EPA Submission on Planning Advice Request for Stephen Road Multi-Level Warehouse

I am writing in response to your request for the NSW Environment Protection Authority (EPA) to provide comment on the Environmental Impact Statement (EIS) for the proposed Multi-Level Warehouse (SSD-65924461) at 49-61 Stephen Road, Banksmeadow (the Site).

Appendix A – NSW Environment Protection Authority (EPA) Submission on Environmental Impact Statement (EIS) for proposed Stephen Road Multi-Level Warehouse (SSD-65924461), 49-61 Stephen Road, Banksmeadow.

- Site Boundary
- Area 1
- Area 2
- Area 3
- Area 4
- Area 5
- Area 6
- AST Farm - Footprint to be checked post demolition

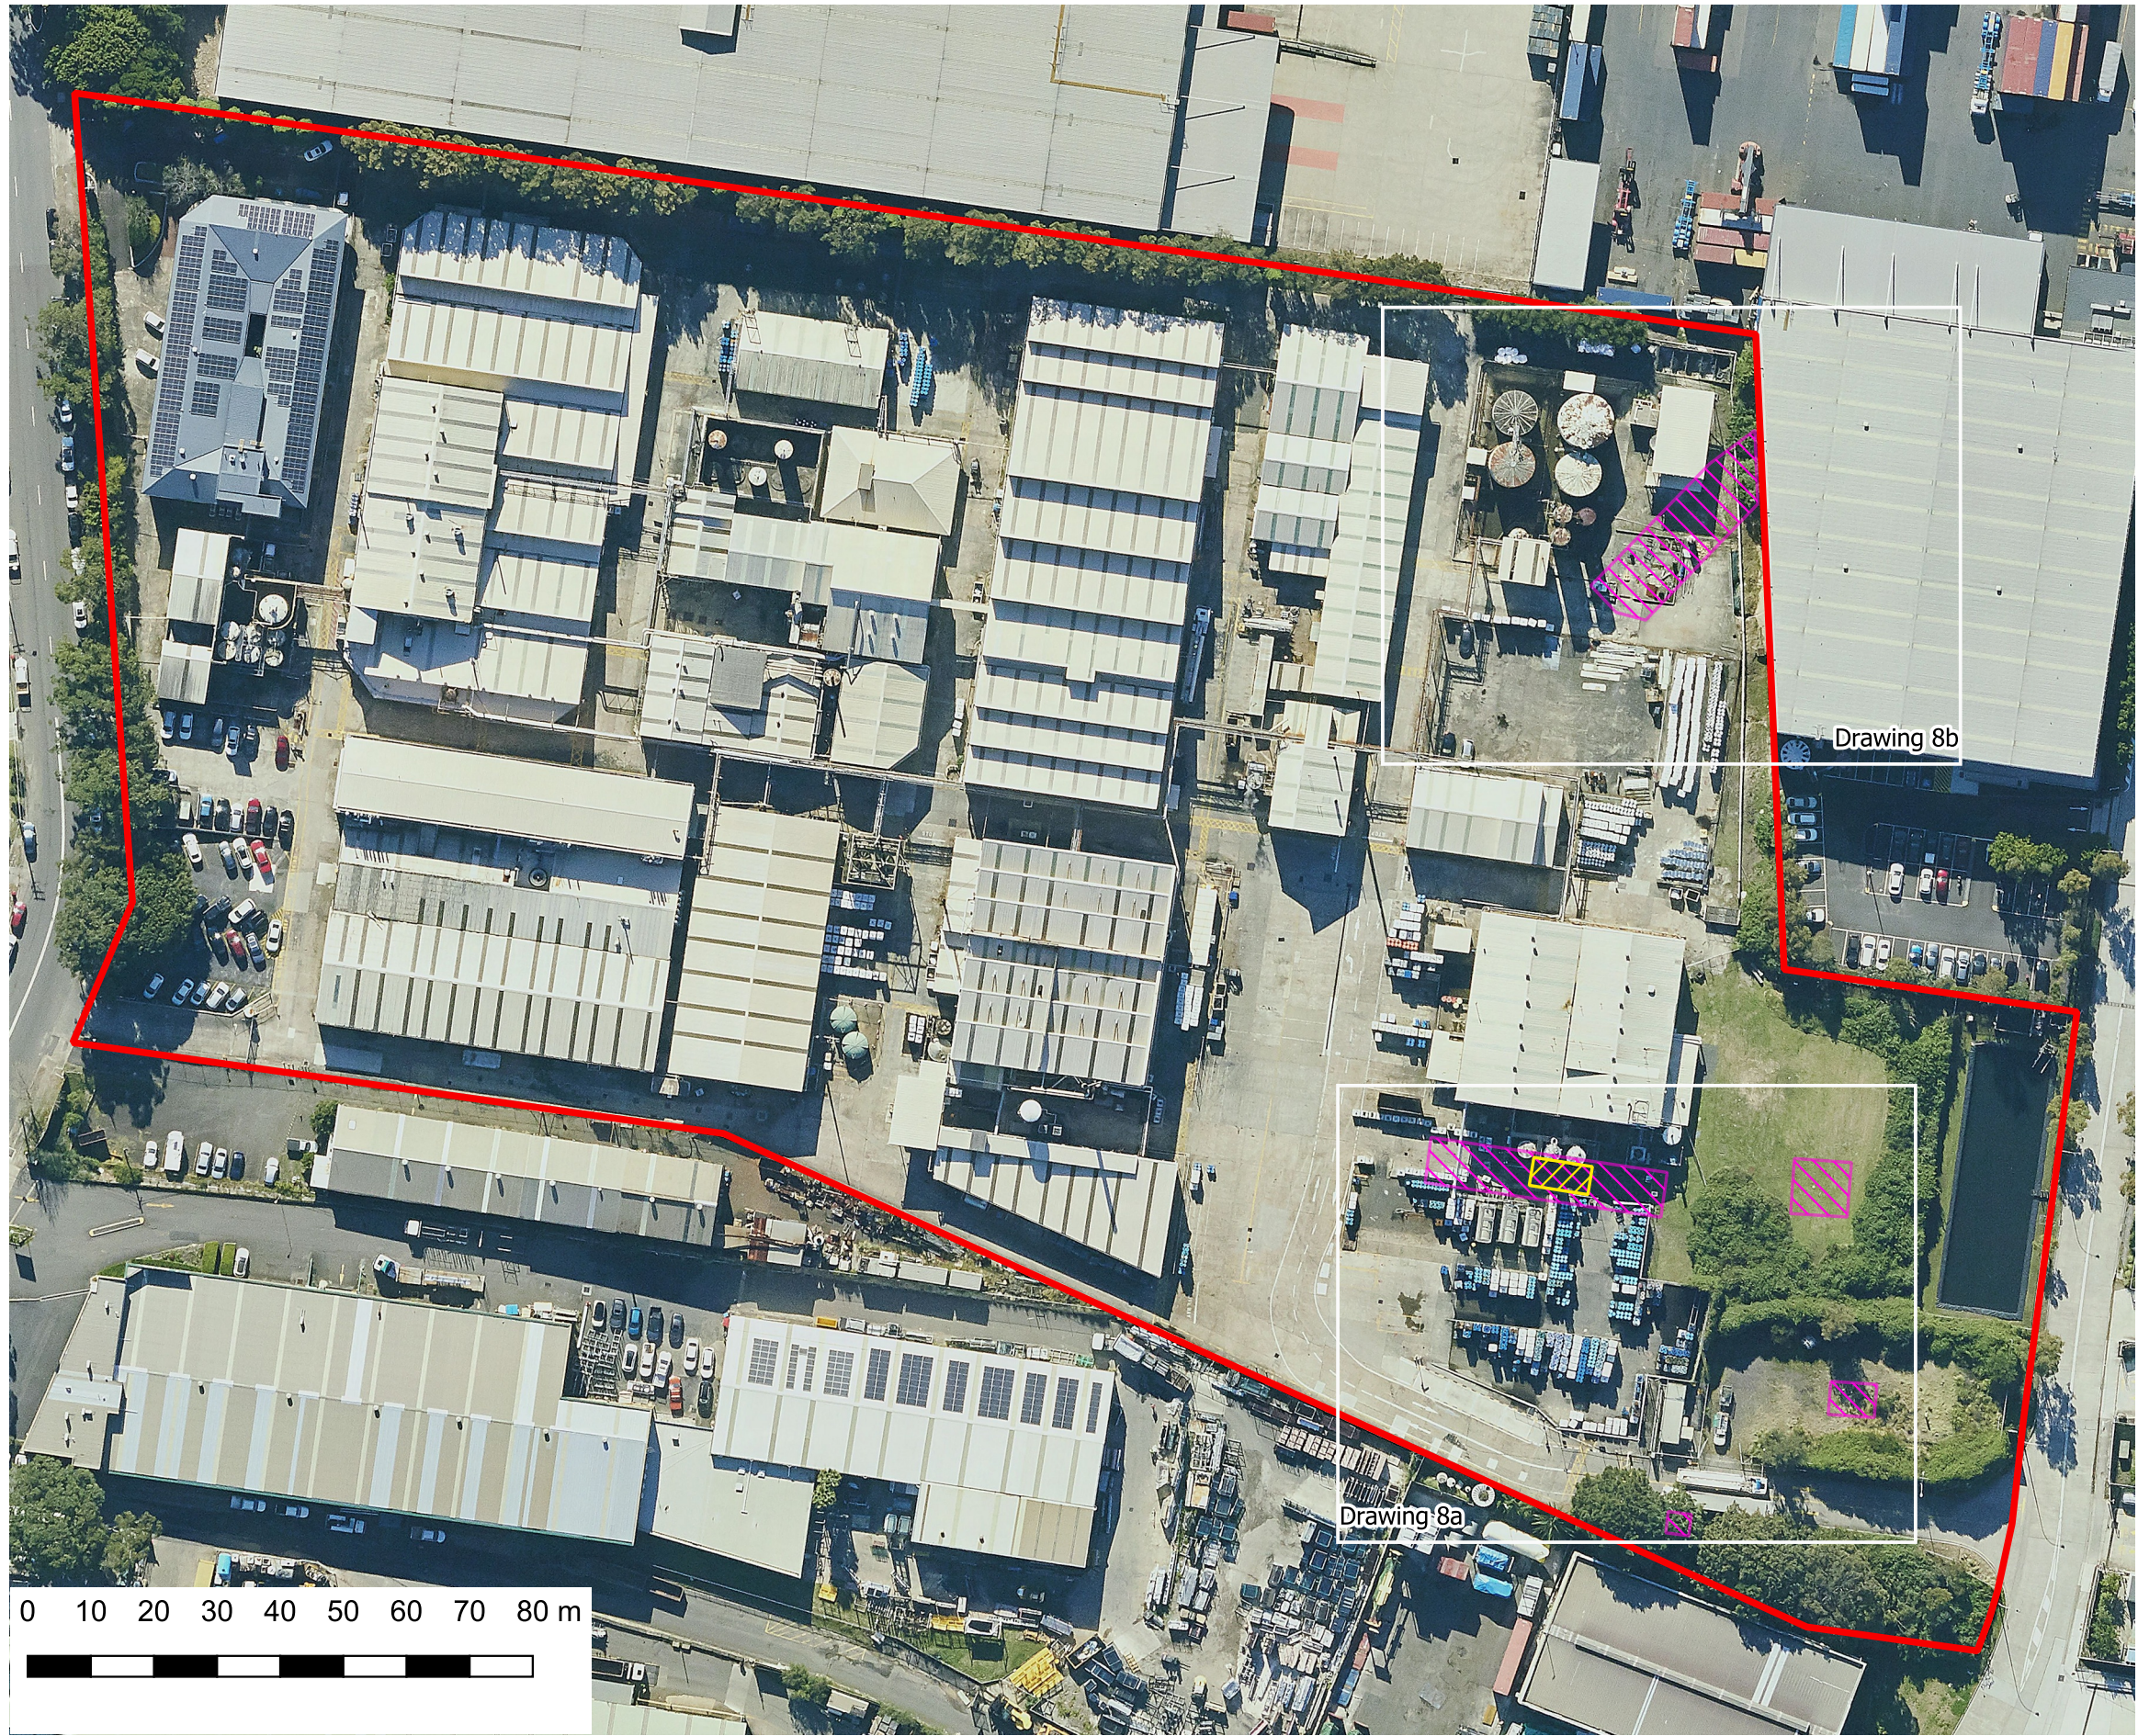
There is existing infrastructure and buildings currently on the Site, and as a result, the actual or potential extent of soil contamination may be underrepresented. The EPA recommends that additional data-gap investigations following the demolition and removal of infrastructure may be required to characterise contamination in potential source areas that have otherwise been inaccessible.

- b) Obtain interim advice from the appointed NSW EPA Accredited Contaminated Sites Auditor regarding any potential evidentiary gaps in source areas that were previously inaccessible following demolition activities to grade and prior to disturbance of sub-surface materials.
